File No: 2019/123712  
Our Ref: R/2017/28/A  
Your Ref: SSD 8993

**State Significant Development SSD 8993 – SCEGGS Darlinghurst concept approval of the 2040 Masterplan and Stage 1 works**

## **ATTACHMENT A**

Drawing Title
**OPTION A
DEMOLITION PLANS**

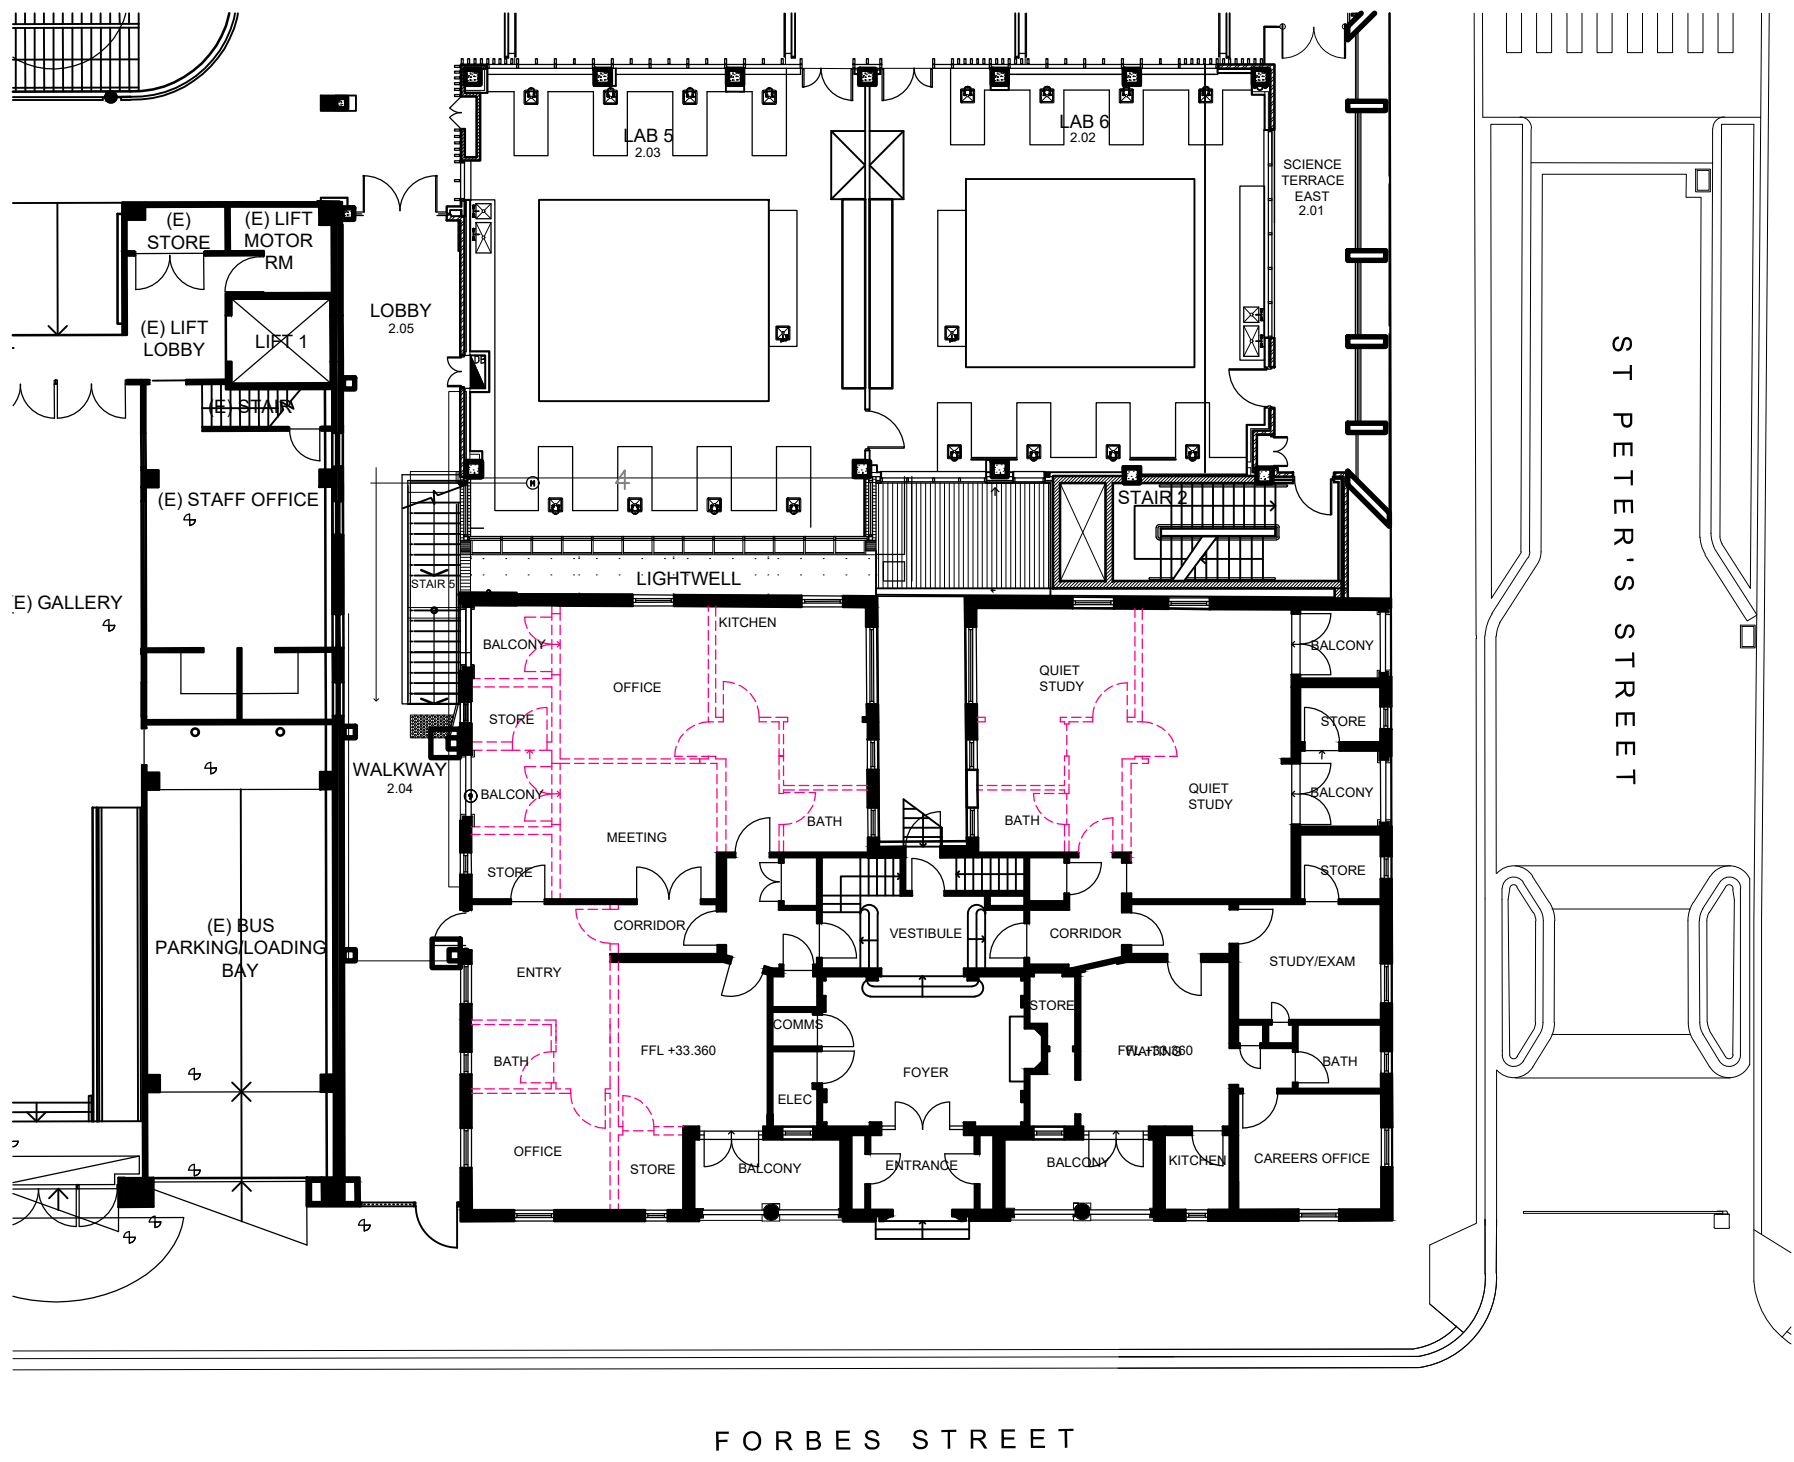
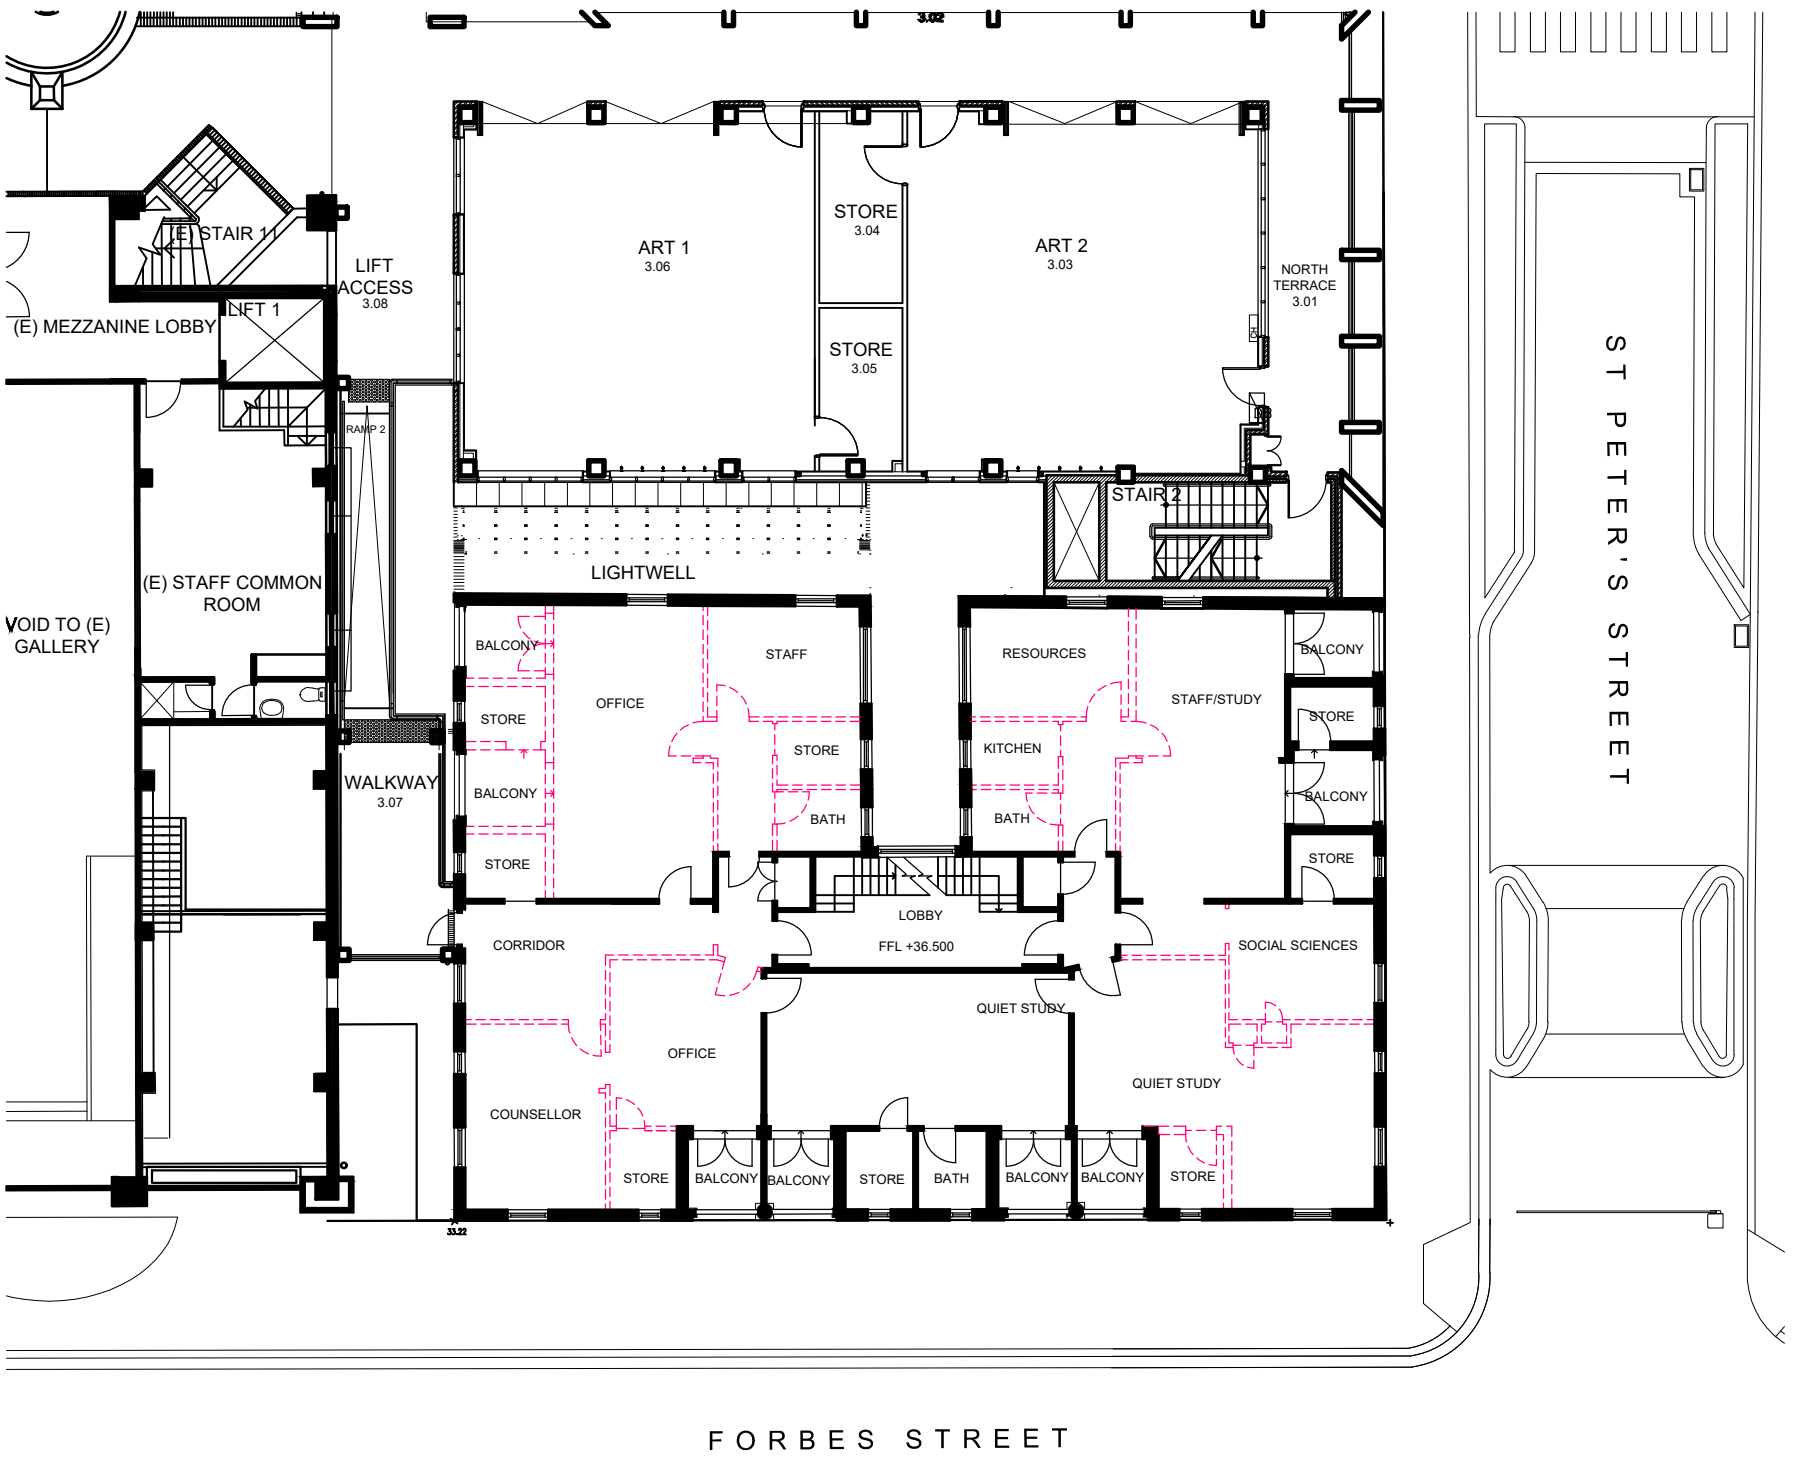
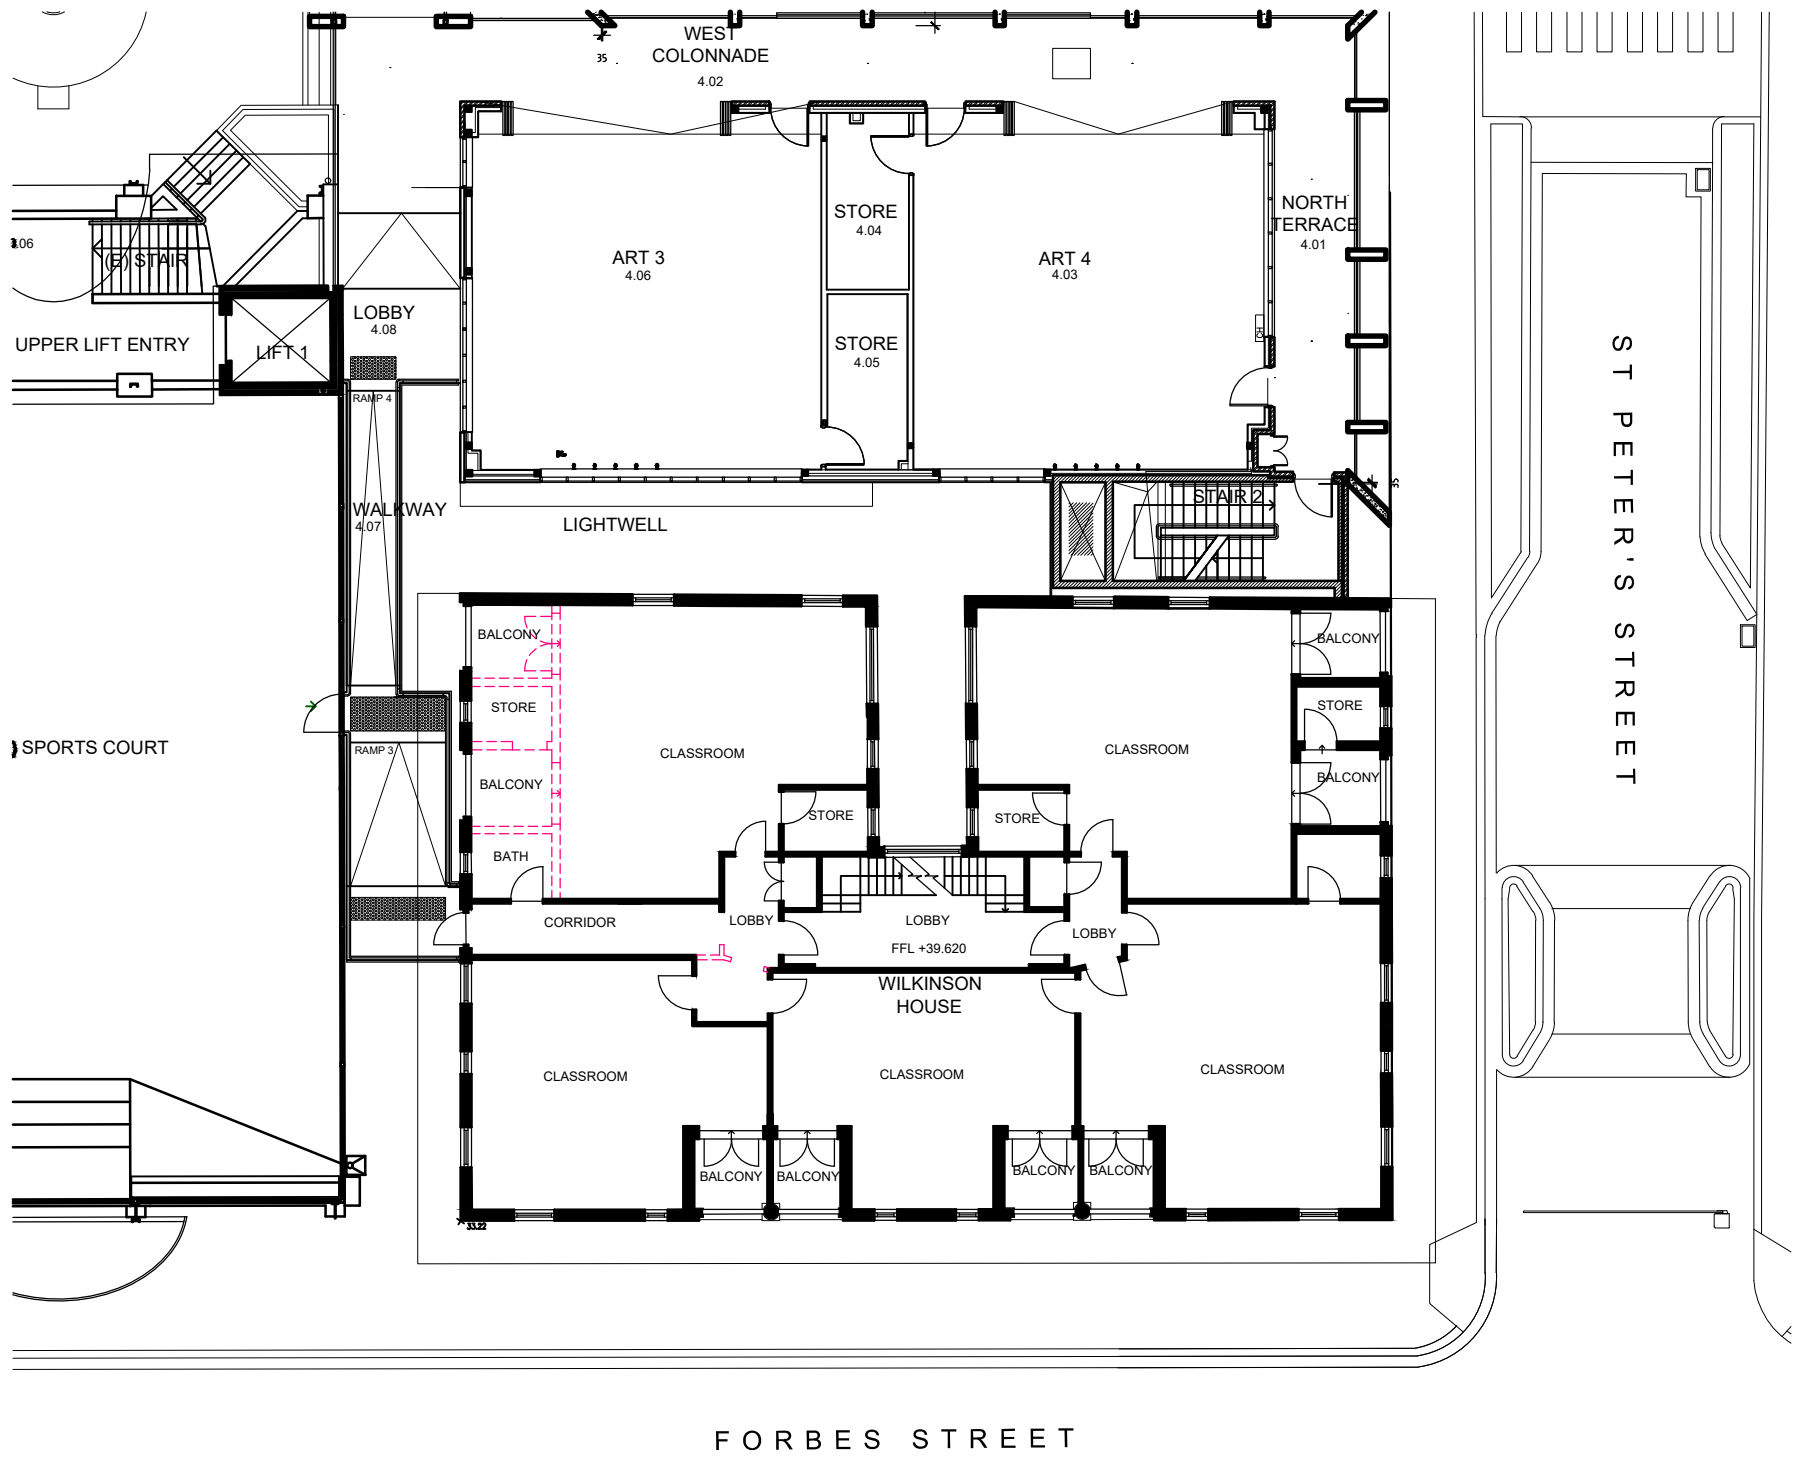
The Applicant claims that the subject building does not adequately accommodate their desire for larger learning spaces and assesses the significance of Wilkinson House as 'moderate' significance to justify its demolition.

Prior consultation with the City has consistently advised that demolition of the heritage item and contributory item is not supported. The loss of Wilkinson House would be significant and unacceptable. .
